This is a re-submission of previous retrospective Planning Application CM/38/21/PL with removal of the request to lay 'new shingle to existing made ground'.

**As-Existing Elevations
with Proposals**

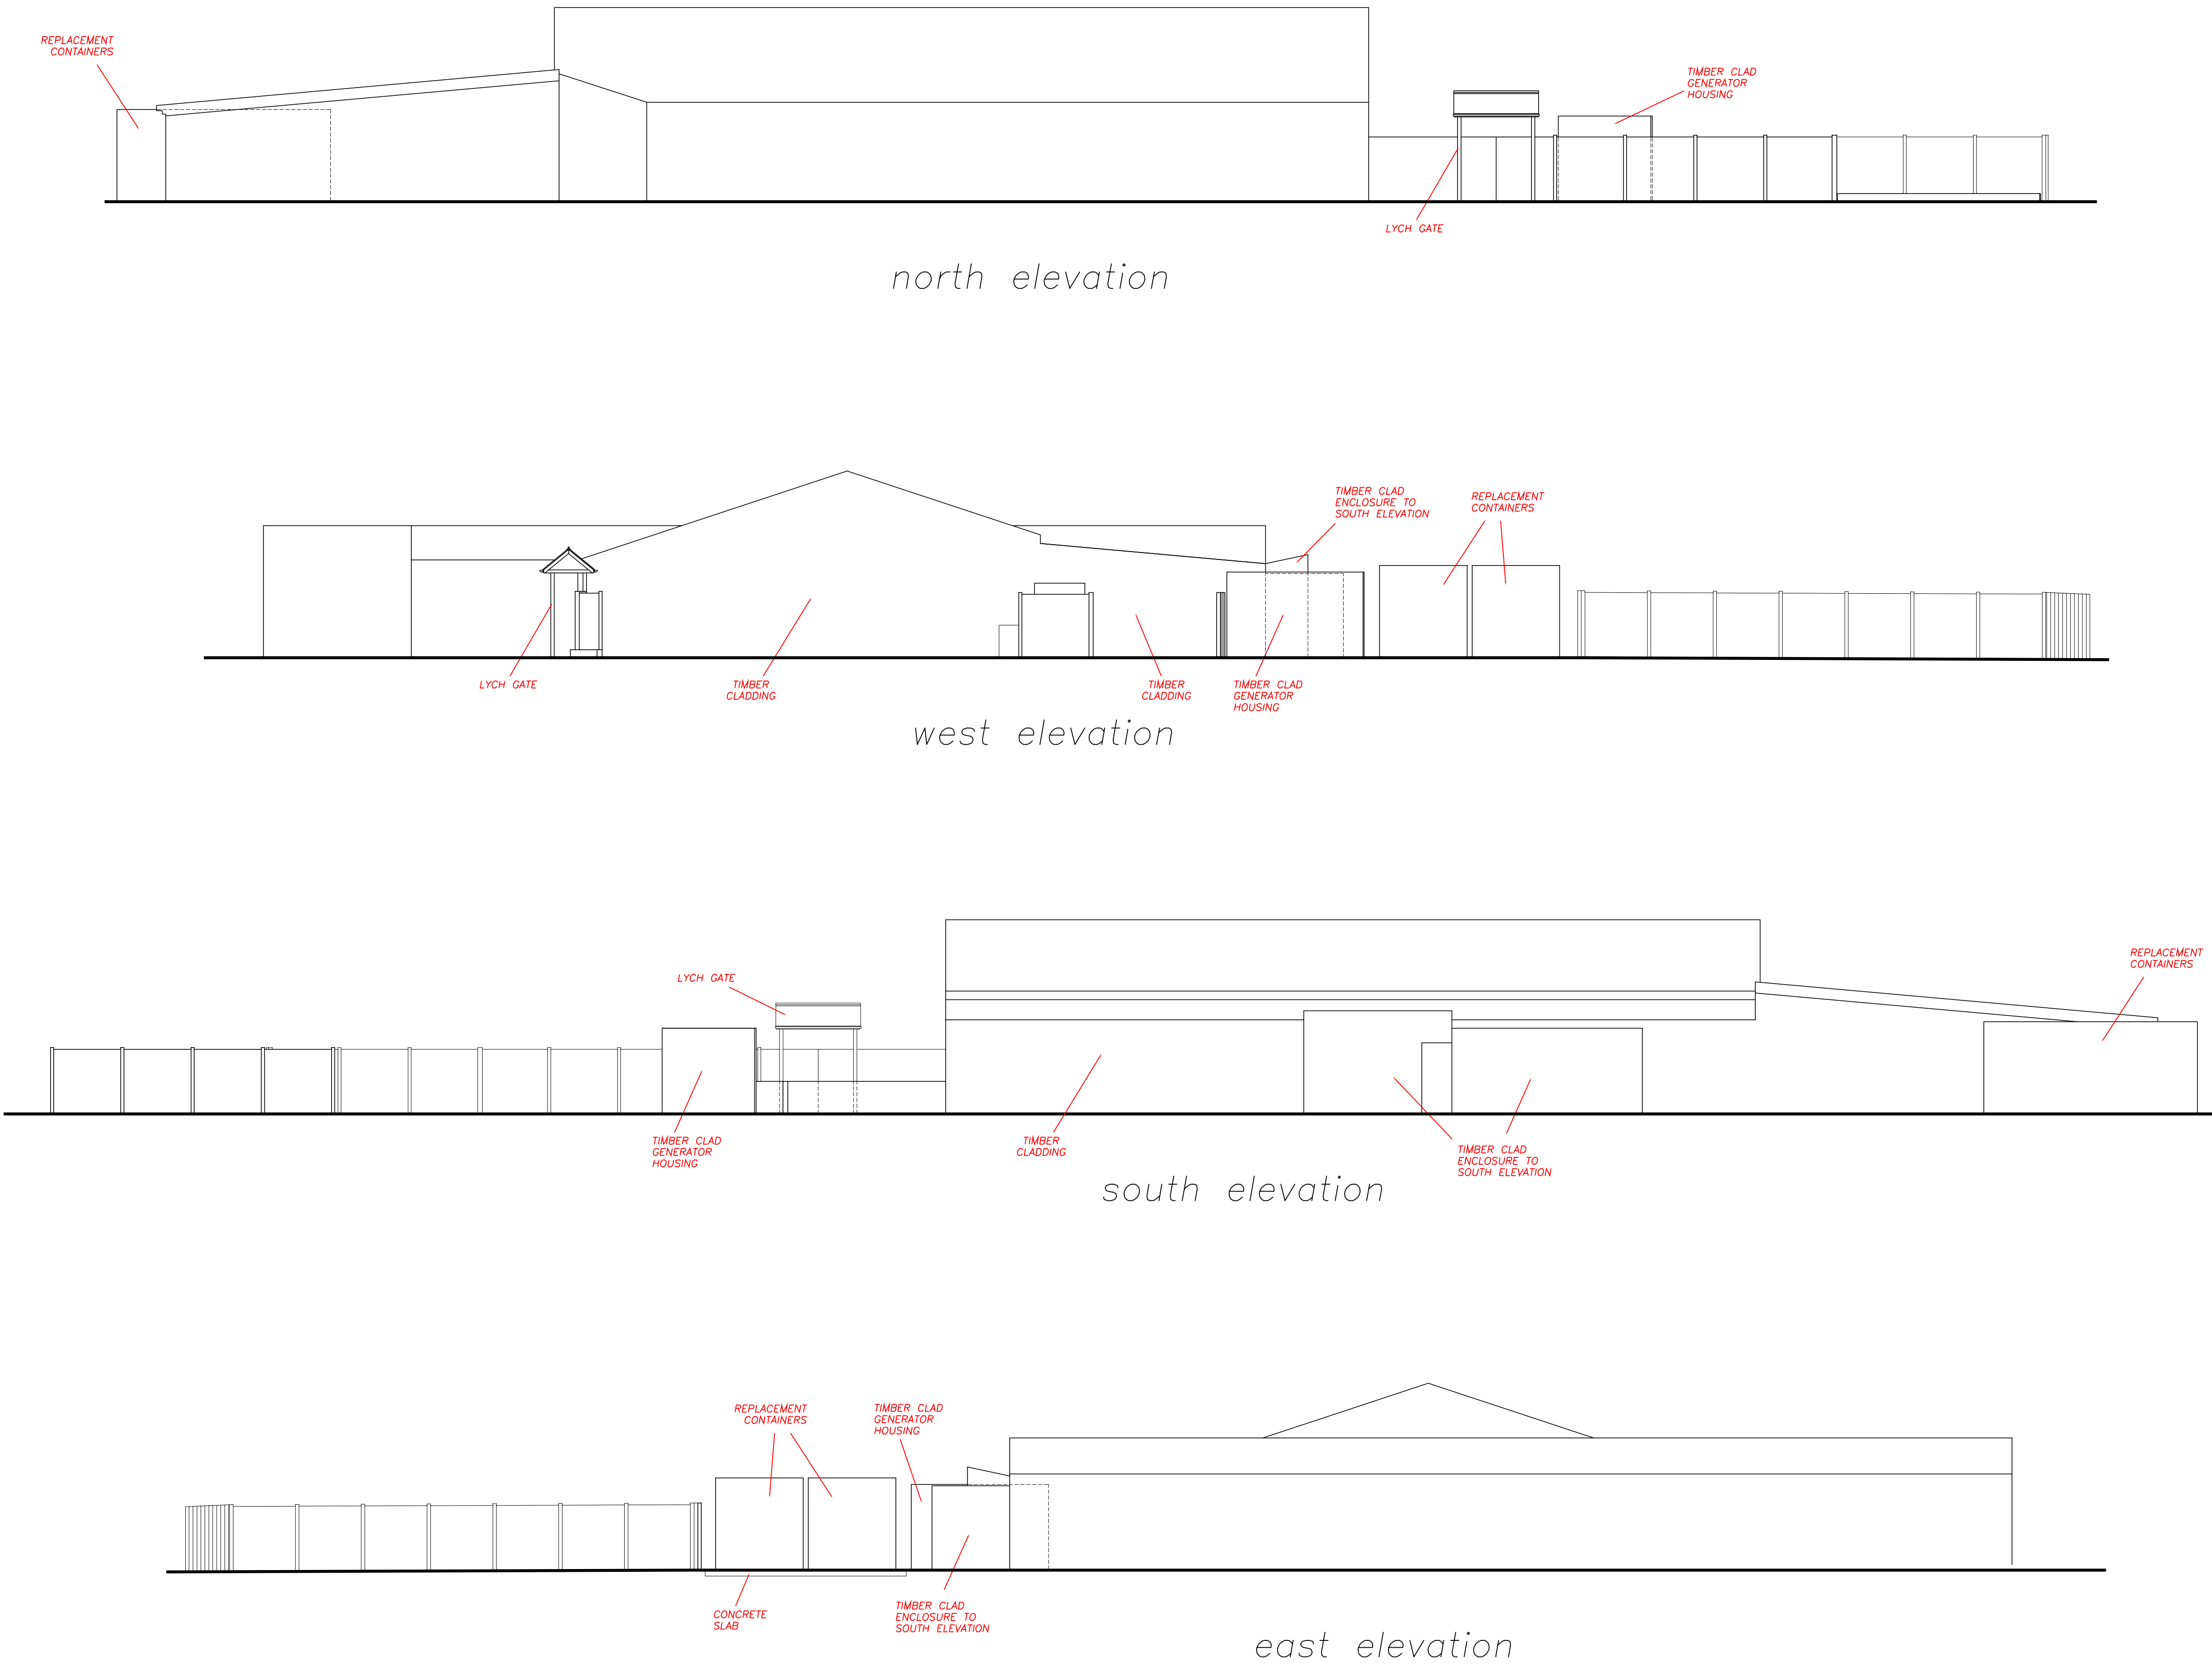
The timber cladding on the west and south sides of the main building and on the generator housing makes the building and its site stand out visually from its rural setting, in contrast to the original green metal, agricultural-style building which was in keeping with the site's former use as a farm shop. It is assumed that the reason for attaching cladding of this type and colour was specifically to make this commercial building and, by extension, the retail site as a whole, more visible to drivers on the A259. This is in addition to ever increasing roadside signage and recently submitted planning applications for more site lighting, advertising boards and entrance flags. Traffic coming from the east already has to contend with the partially obscured site entrance/exit, while traffic coming from the west is at risk of being distracted by the sight of timber cladding out of character with the surrounding area. This section of the A259 already has a history of accidents and near misses, allowing further distractions is irresponsible and a risk to public safety.

Timber cladding on this scale also increases the fire risk to the commercial building itself, the other businesses on the site including The Bald Kitchen fast food cafe situated inside a shipping container with flammable plastic foliage cladding, and the adjacent Grade II Listed cottage with its external domestic fuel tank situated close to the boundary fence with the site. ADC's Fire Officer has already stated that the nearest fire hydrant is further away than it should be for commercial premises. Fire issues need to be given serious consideration, in view of the fact that people will be sleeping in tents,

**As-Existing Block  
and Location Plans**

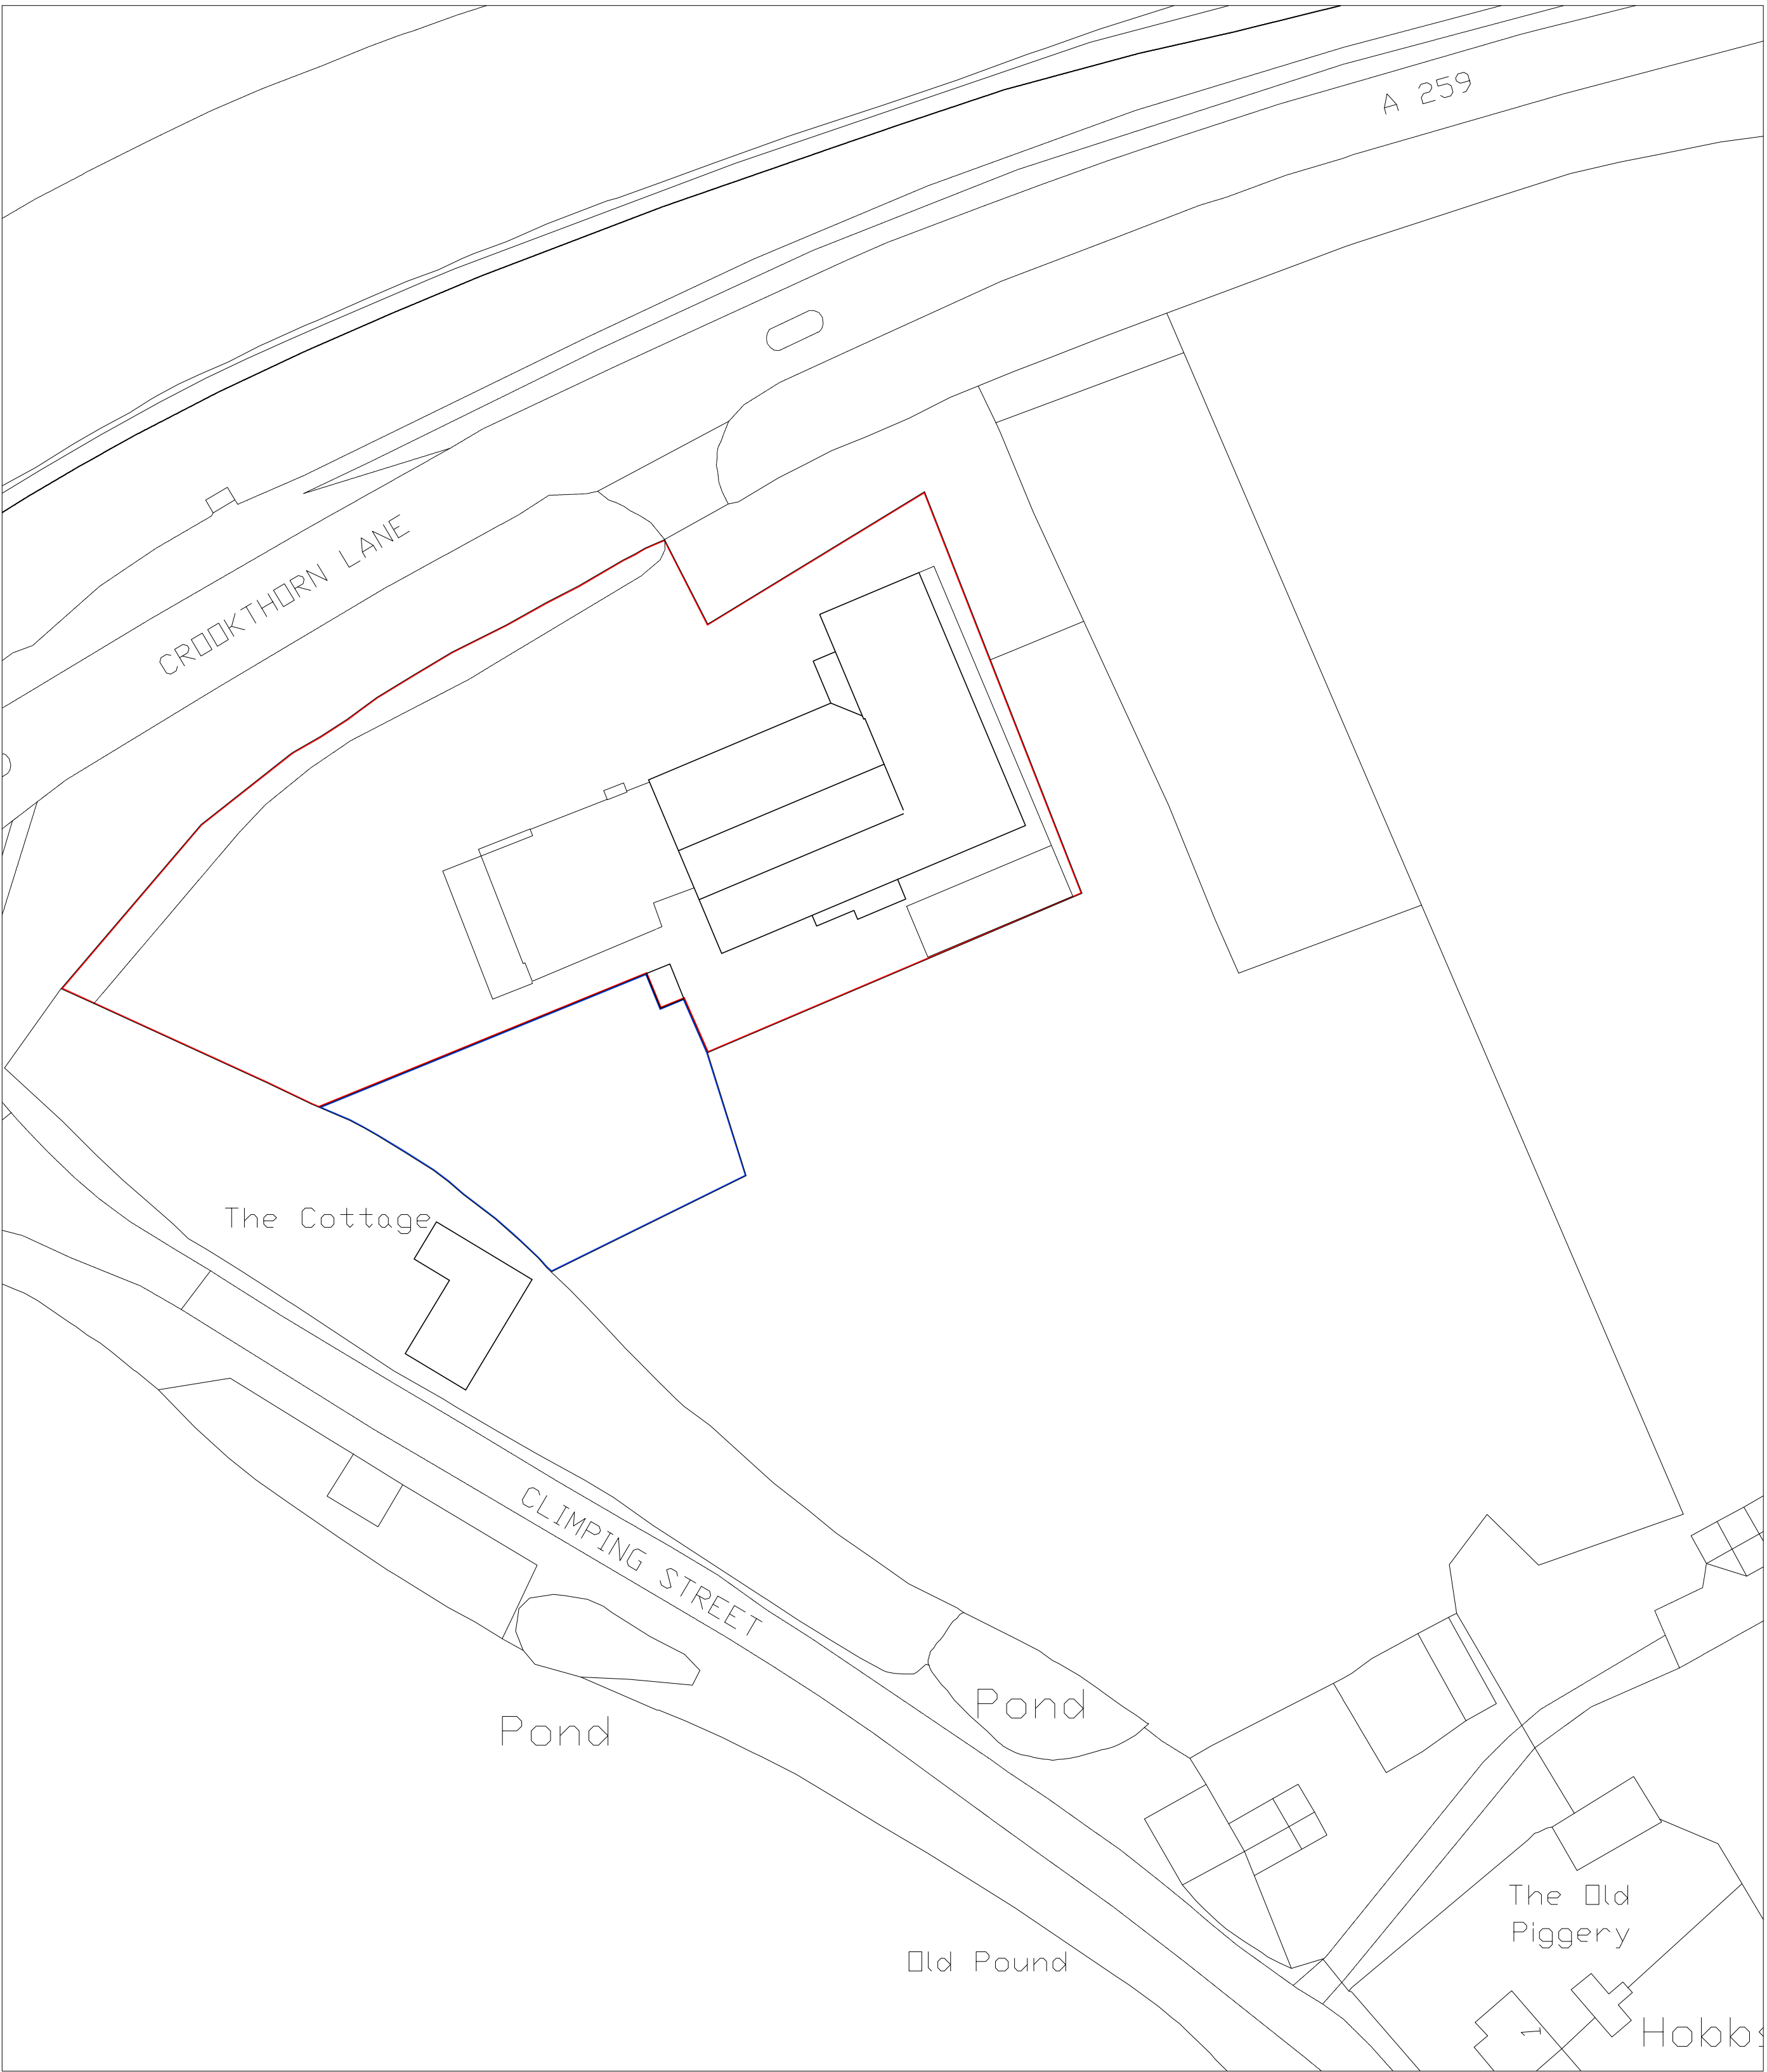
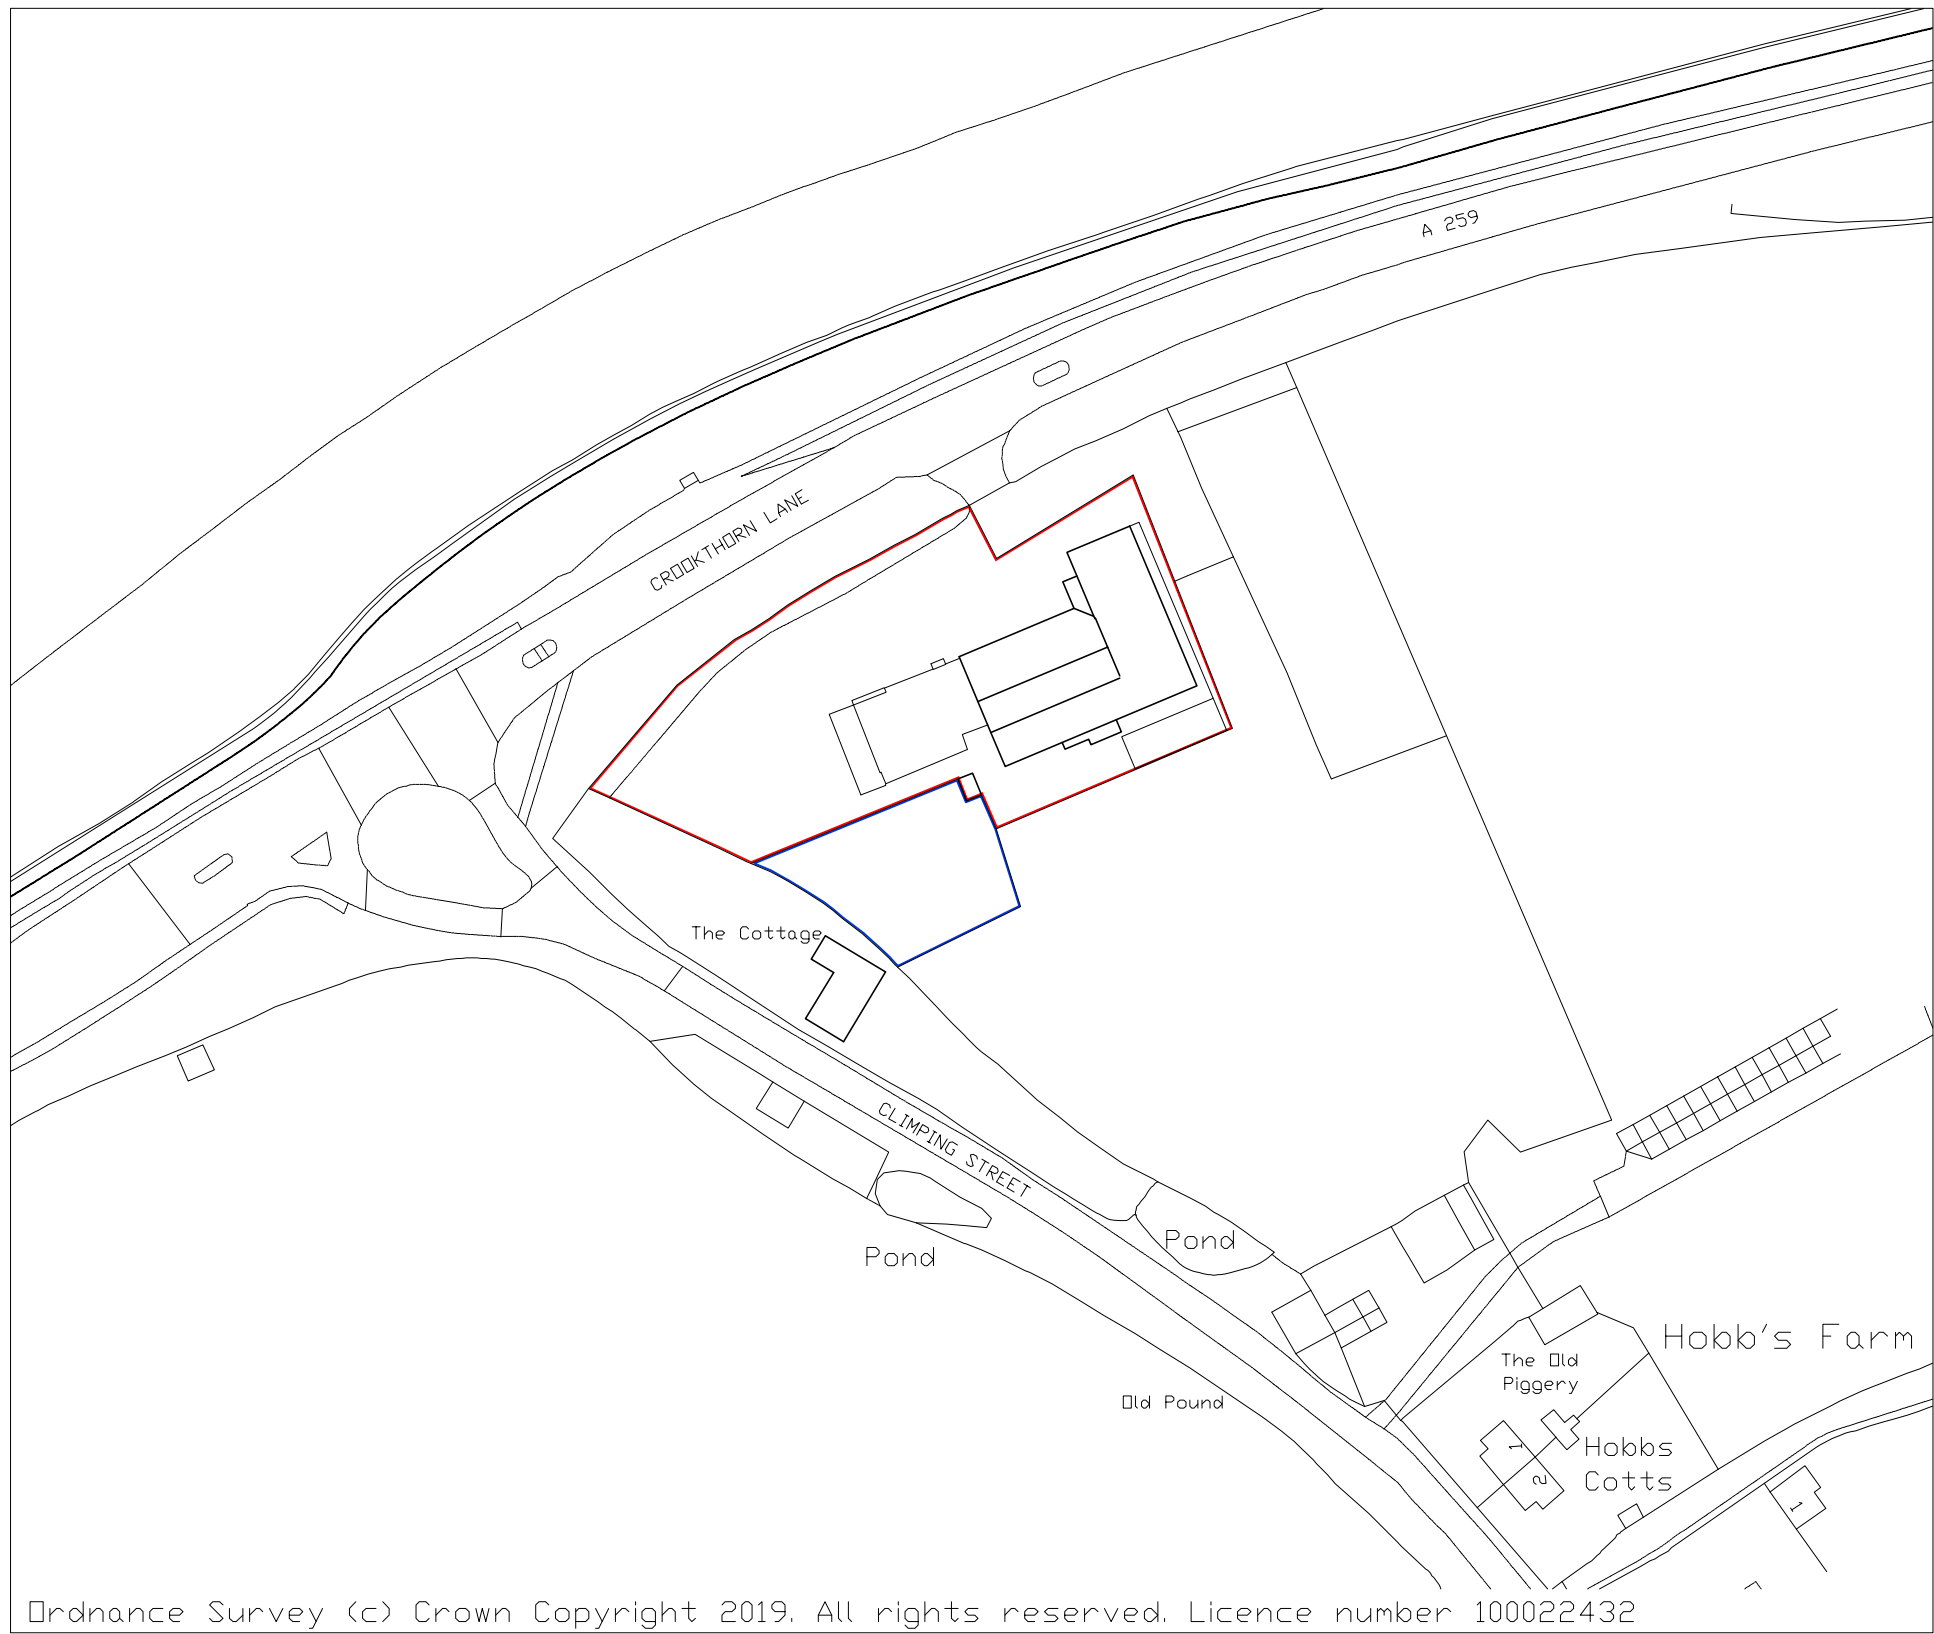
To date, the shingled area is still in place without planning permission, and with issues remaining over whether it was added to existing made ground, as stated by the Applicants in CM/38/21/PL, or whether it was part of a grass field, complete with polytunnel before groundworks commenced, as stated by local residents with supporting photographic evidence. It is, therefore, realistic to expect that as soon as this latest application for retrospective planning permission is approved, the refusal of the shingled area will be appealed.
